FINAL DRAINAGE REPORT
for
WINDERMERE FILING NO. 1

Colorado Springs, CO

November 19, 2021

SF-21-026

PROPOSED
DRAINAGE MAP

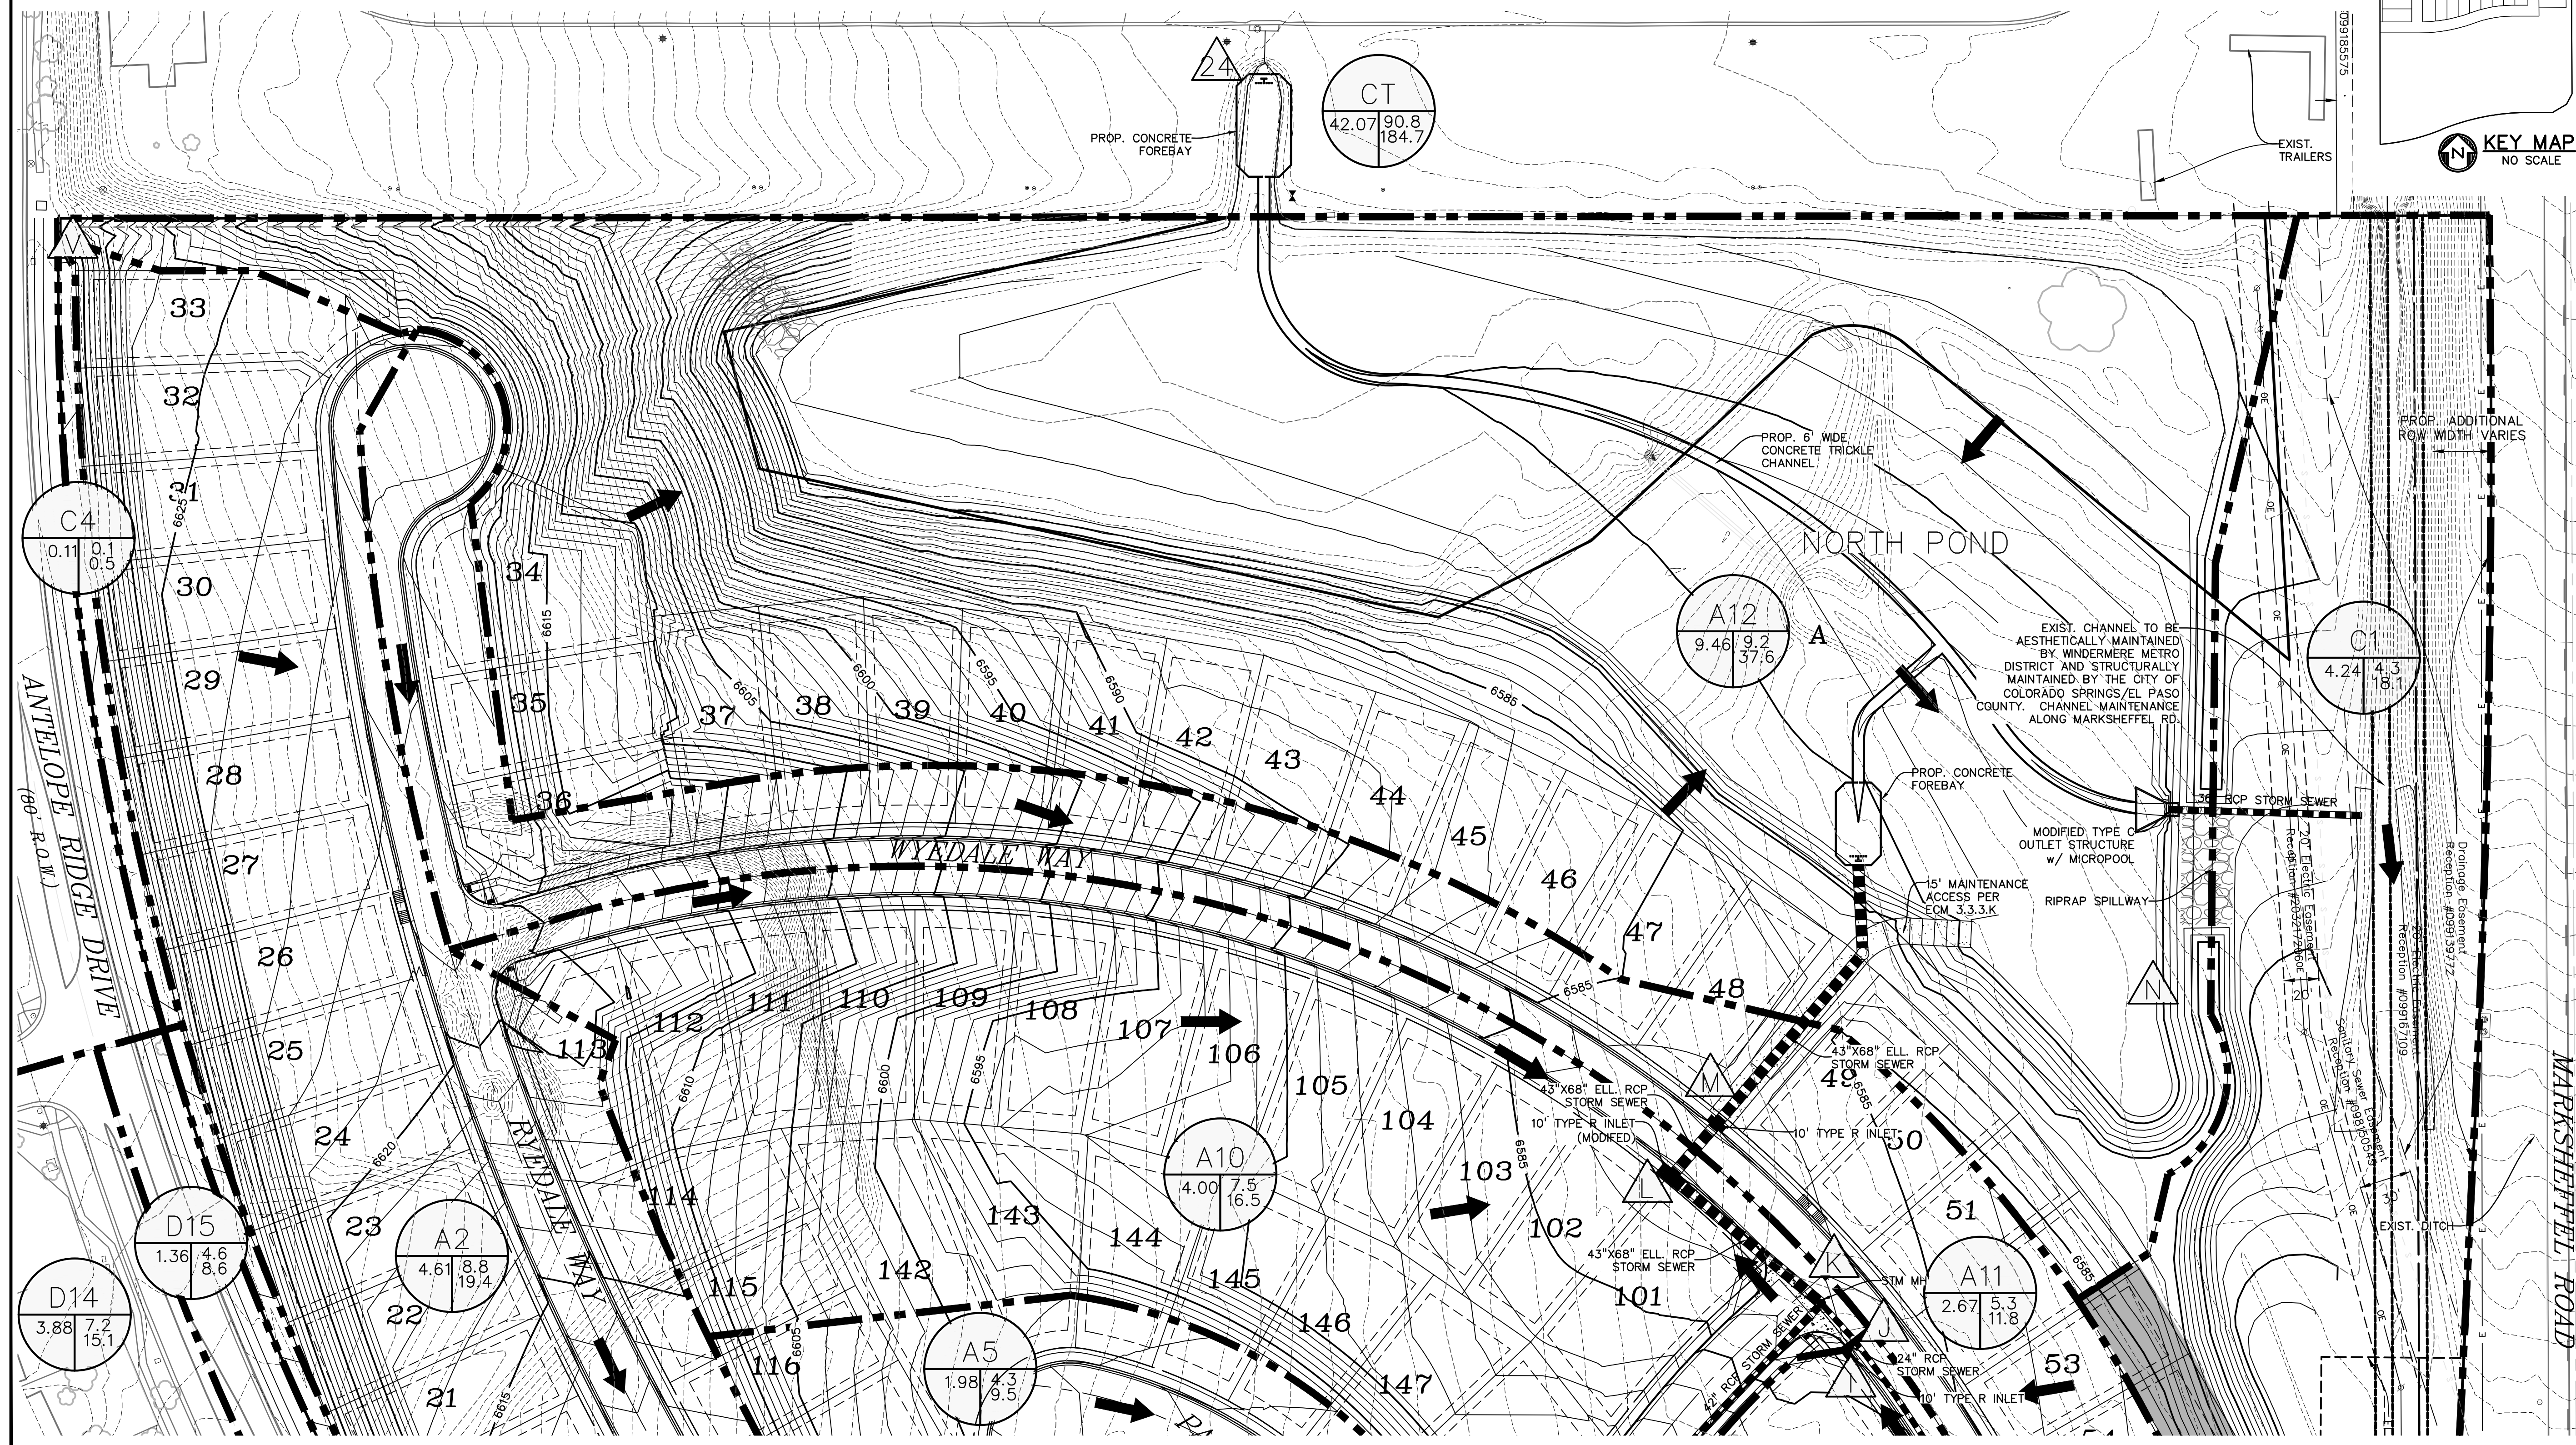
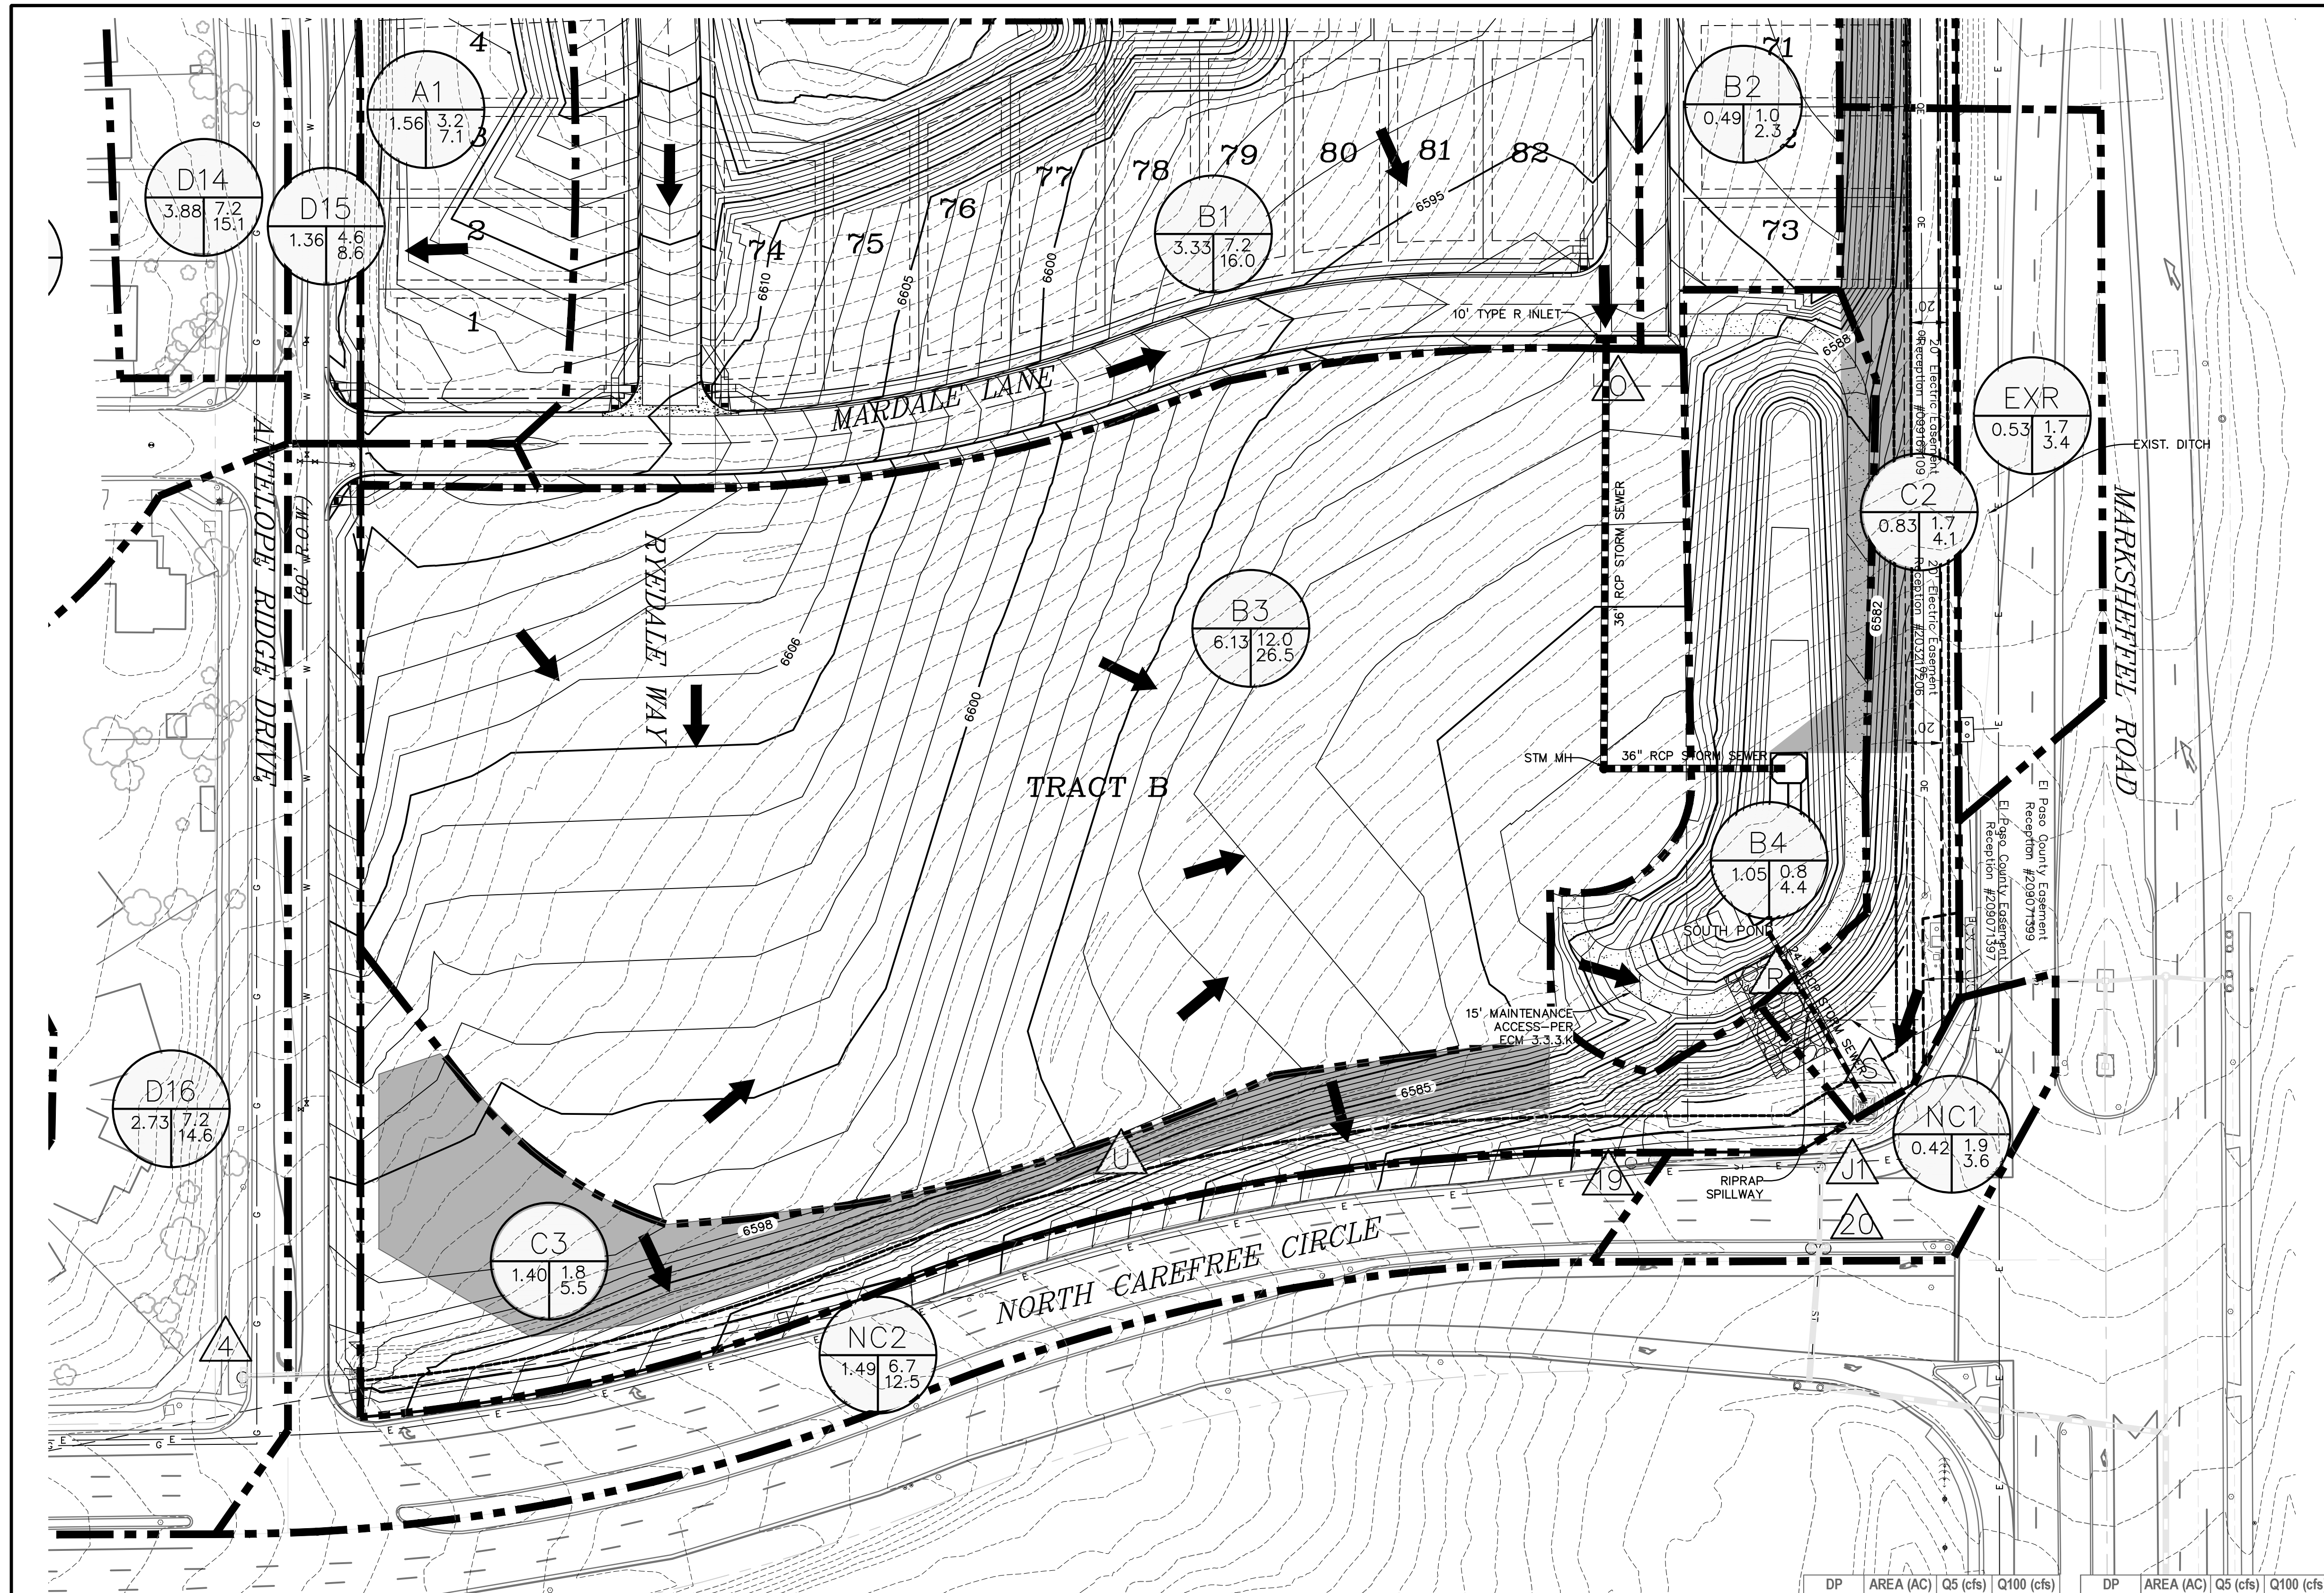
Plan says inlet is to be modified. Please discuss

Flows don't match plan
